Our Ref: DOC19/387091
Your Ref: Your letter dated 1/05/2019

Re: Cairncross Waste Management Facility Expansion SSD 5792 Response to Submissions

Thank you for your letter dated 1 May 2019 about the Cairncross Waste Management Facility Expansion (SSD 5792) Response to Submissions seeking comments from the Office of Environment and Heritage (OEH). I appreciate the opportunity to provide input.

Figure 1-2 Site layout

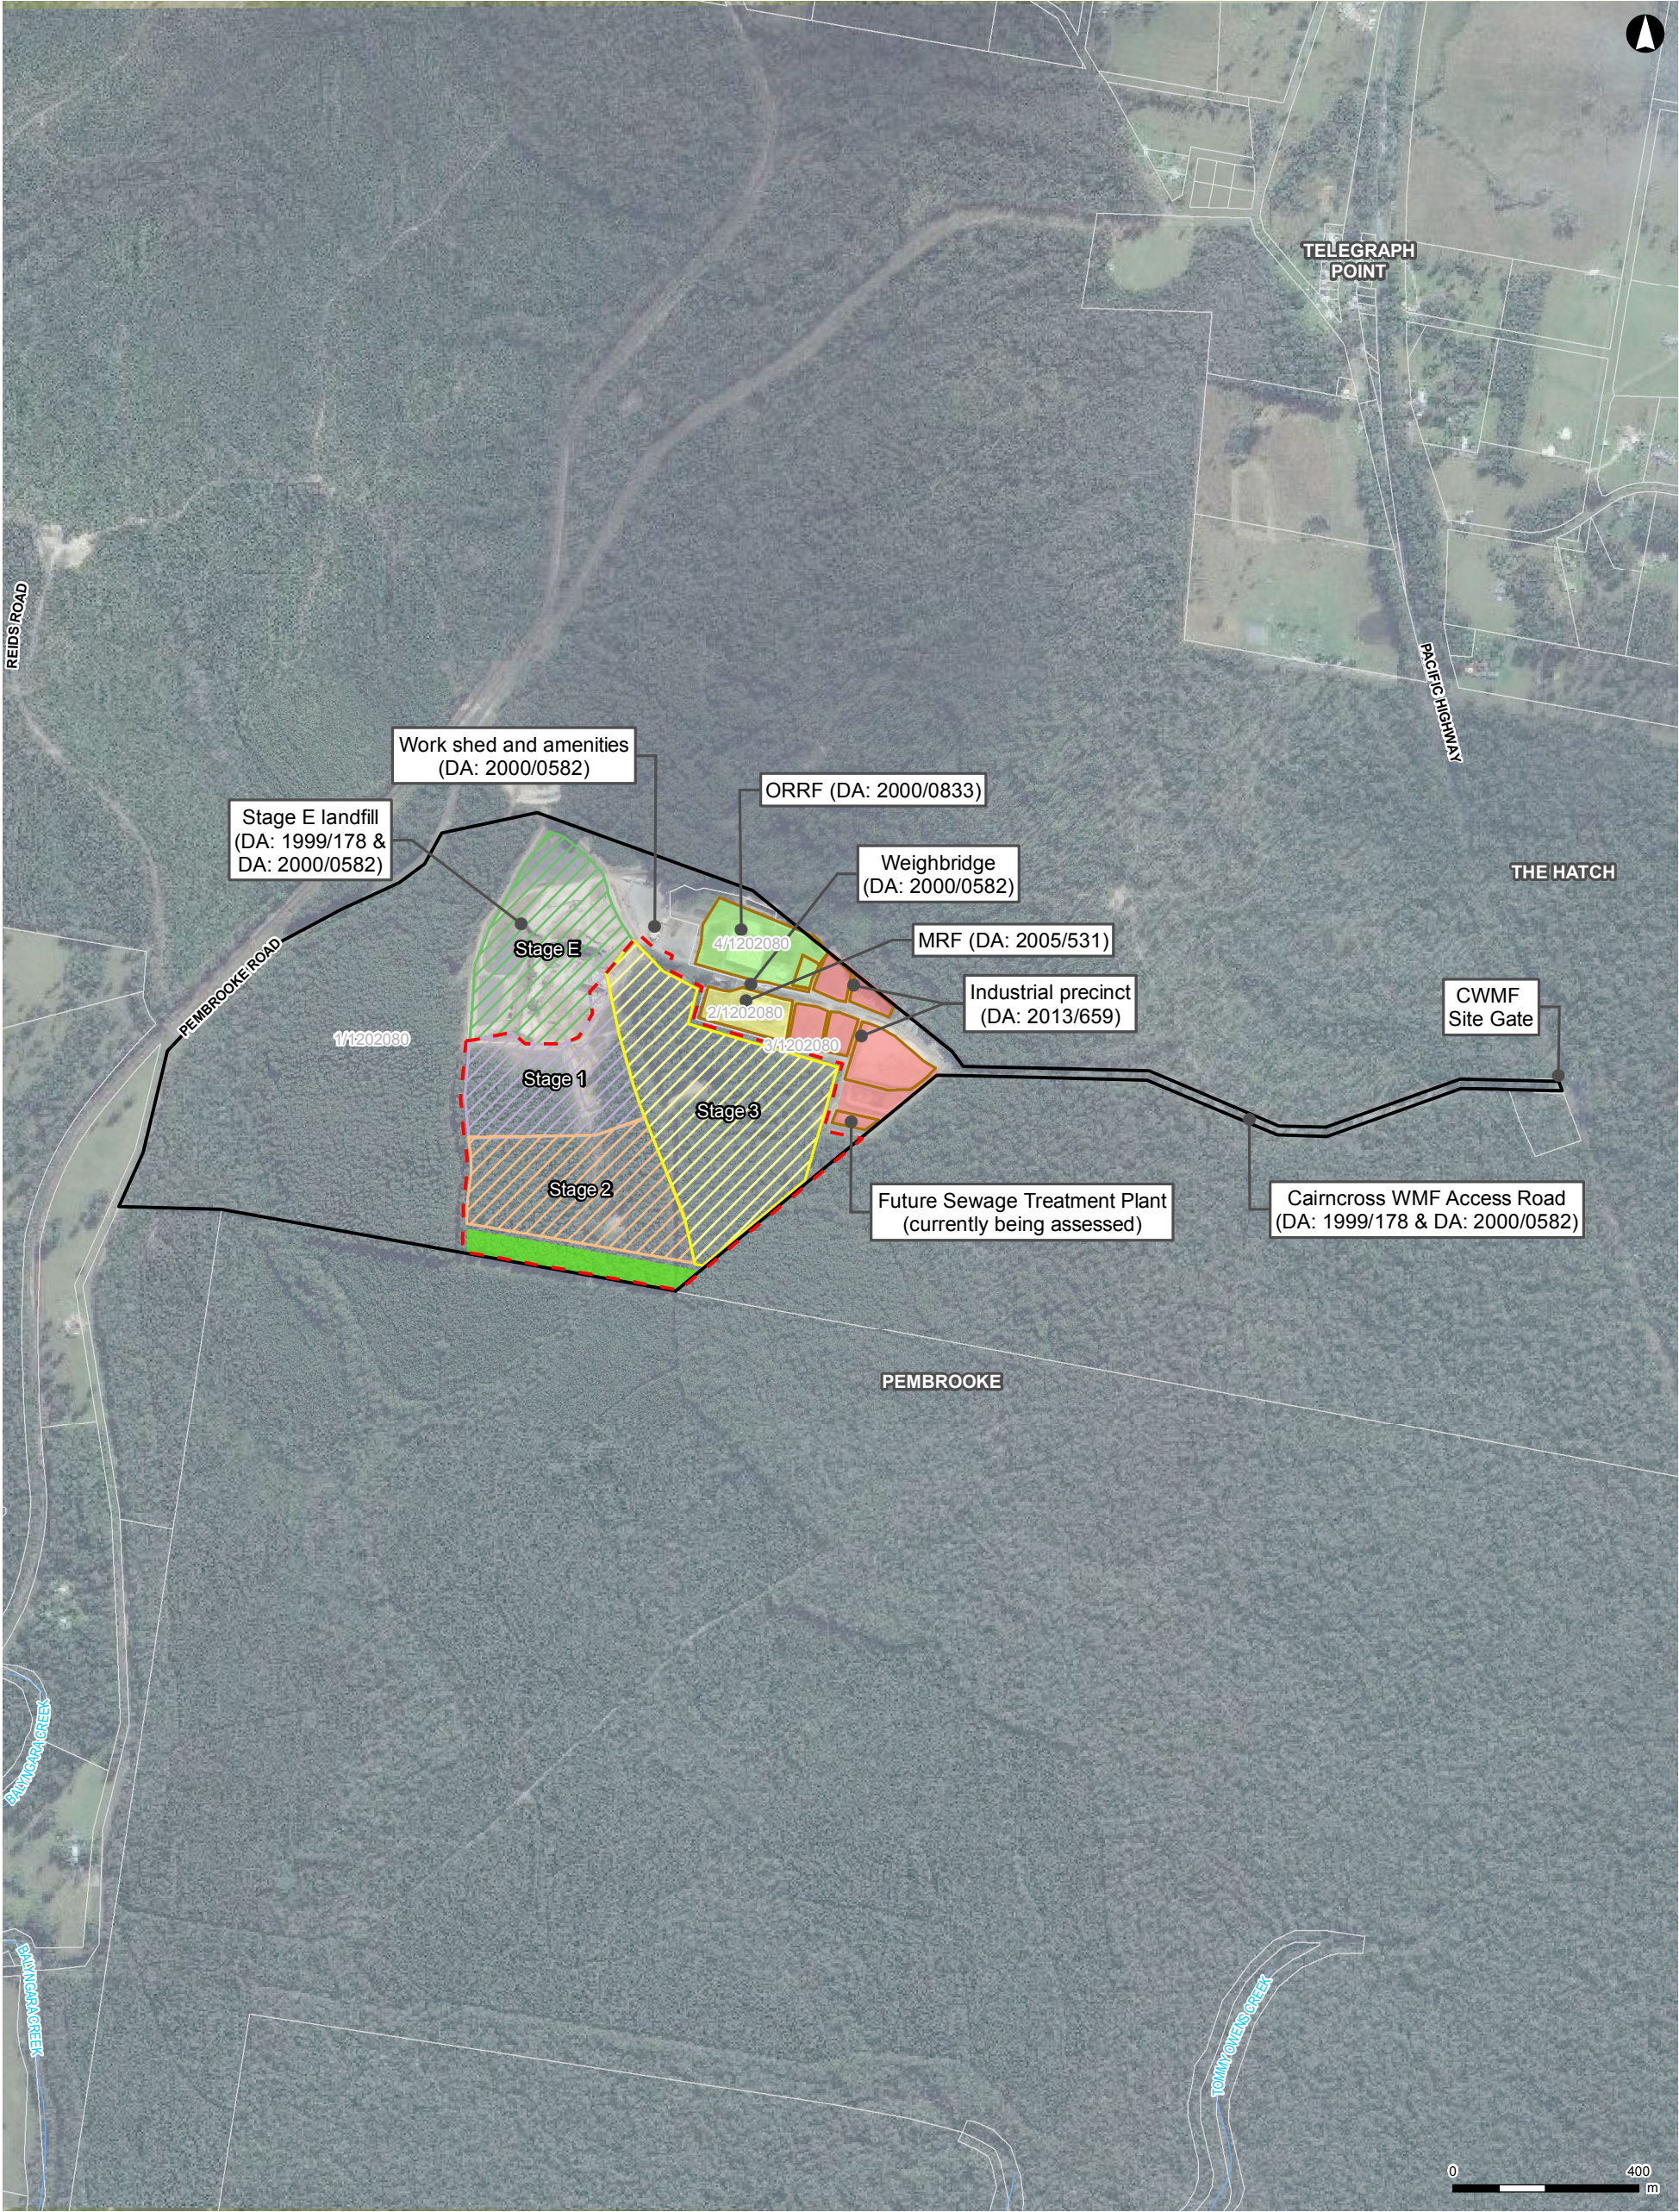
Your letter addresses the issues the OEH raised in our Response to Submissions letter dated 7 March 2019 regarding a vegetated buffer to the Rawdon Creek Nature Reserve (NR) and the width of the koala corridor along the southern boundary of the waste management site. It identifies why a 50m buffer was considered unnecessary given it is argued the Strategic Fire Advantage Zone (SFAZ) will adequately mitigate potential environmental impacts including visual impacts, litter, weeds, fauna habitat and water. The most recent recommendation from the OEH was that this be a minimum 10m wide buffer for both visual and ecological reasons. It is disappointing this has not been achievable.

In relation to the koala corridor, the OEH accepts that there will be an encroachment from the Stage 2 sediment basin and that this cannot be avoided due to site constraints. We note the aim of the koala corridor is to facilitate continued movement of koalas between larger patches of habitat to the east and west following removal of vegetation for the waste management facility. The need to remove understorey and shrub vegetation and continually slash and to rake under the trees in the koala corridor will mean this area has reduced value for other native species, although it is acknowledged that koalas will still be able to use it.

Your letter references the density of koala feed trees but does not quantify the proposed density. It also references pet dogs not being present with the correlation that koalas will not be impacted. Wild dogs are also a significant threat to koalas (see https://www.aph.gov.au/Parliamentary_Business/Committees/Senate/Environment_and_Communications/Completed_inquiries/2010-13/koalas/submissionsaccessibilitytrial/sub018).

The OEH recommends the Operational Environmental Management Plan (OEMP) should:

1. be prepared in consultation with the OEH;
2. include a Vegetation Management Plan (as a sub-plan) that describes how the impacts arising from the operation of the waste management facility on the NR will be managed and mitigated to address the *OEH Guidelines for developments adjoining OEH land and water* (<http://www.environment.nsw.gov.au/topics/parks-reserves-and-protected-areas/development-guidelines>);

3. cover all areas of vegetation to be retained, managed and zoned E2 in the future (i.e. the initial offset area to the west, the area to be established as a koala corridor on the southern boundary and the Strategic Fire Advantage Zone);

4. address management of feral animal issues (including foxes and wild dogs);
5. include a reference to the Memorandum of Understanding between NPWS, NSW Forestry and Port Macquarie-Hastings Council regarding waste management and describe how illegal dumping and litter will be managed;

6. address vehicle and track access issues to the NR as discussed in the OEH Guidelines;
7. include details of the fencing to be installed, the timing for its installation and how this will prevent access by koala and other fauna into the landfill site;

8. be provided to the OEH for review after it has been drafted.
